East Pye Solar — Planning Inspectorate Reference EN0110014

Project Reference: EN0110014 (East Pye Solar Project)

Subject: Formal Written Representation — Objection to East Pye Solar Project (EN0110014): Severe Harm to the Historic Setting, Immediate Approach, and Heritage Cluster at Hawes Green / Site 8

Drawing file: published-documents / EN0110014-001286-6.2.7.5.4 Environmental Statement Volume 2, Figure 7.5.4 Site 8 Zone of Theoretical Visibility (Revision 2).pdf

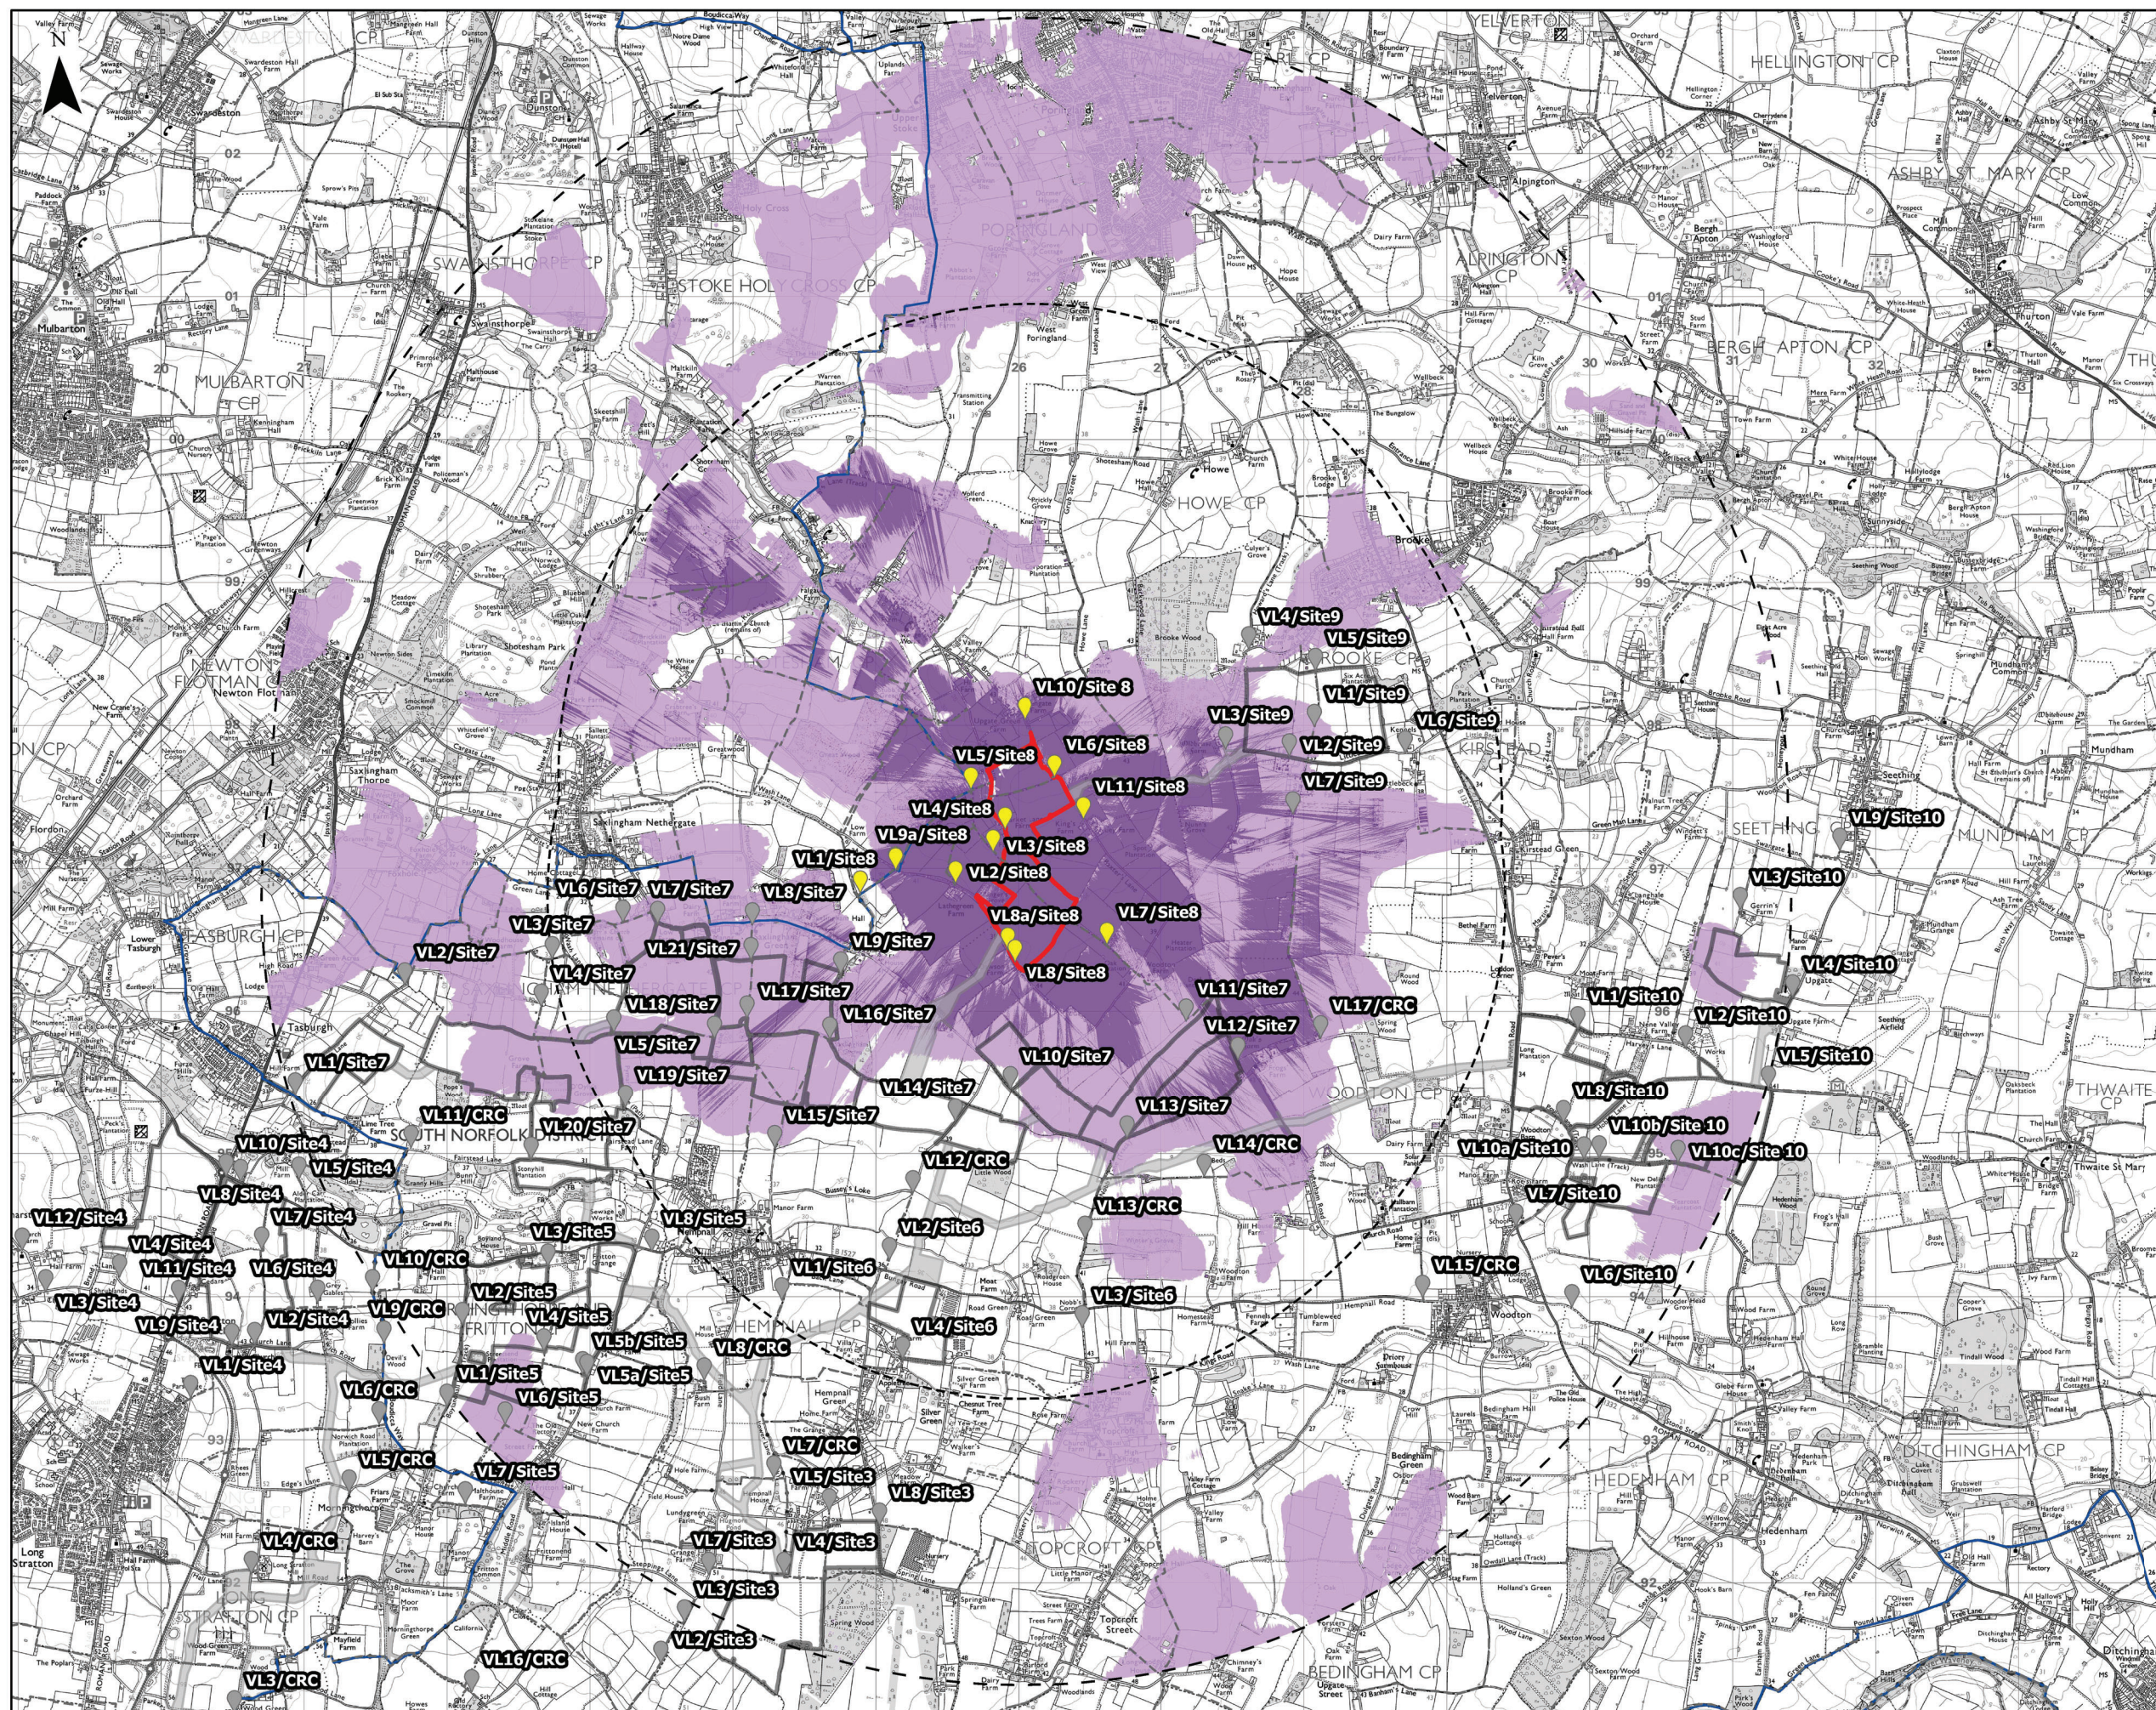
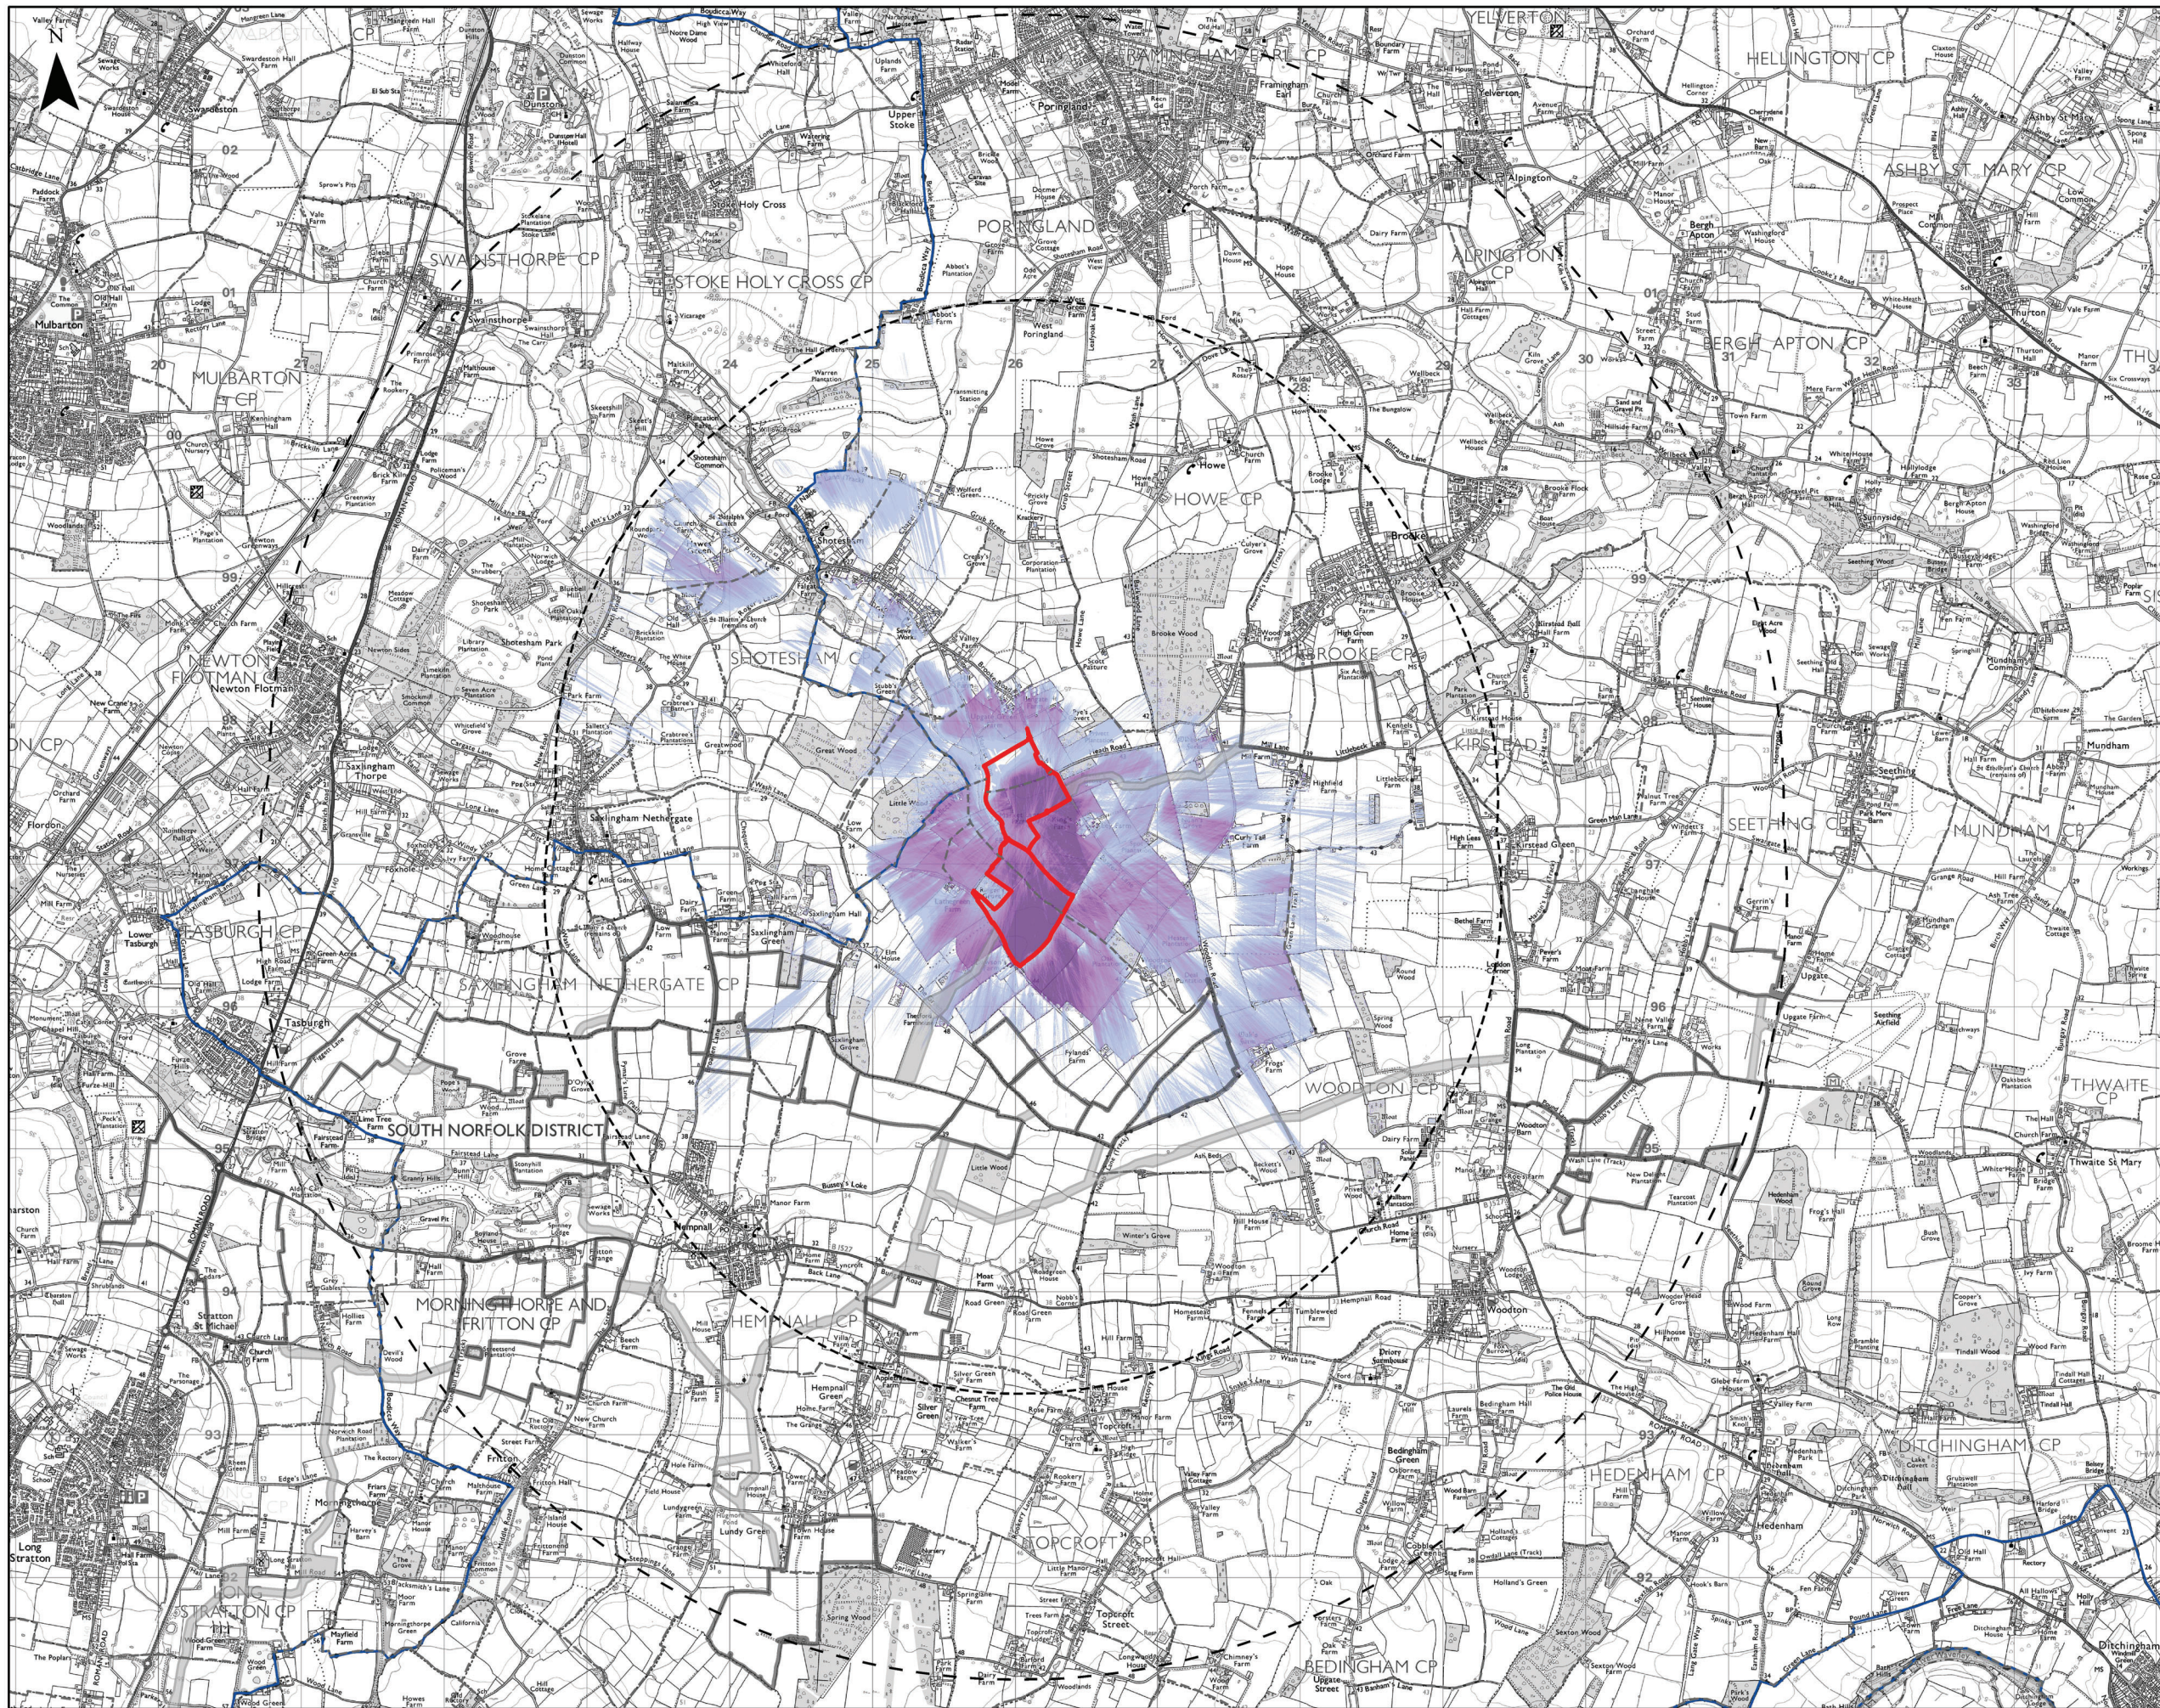
- (a) Require the Applicant to confirm whether Hawes Green falls within the ZTV for Site 8 (Figure 7.5.4) and, if so, to explain why no Residential Visual

Amenity Assessment has been conducted from this location, given that ES Chapter 7 paragraph 7.5.22 acknowledges Shotesham as a settlement from which visual effects are likely;
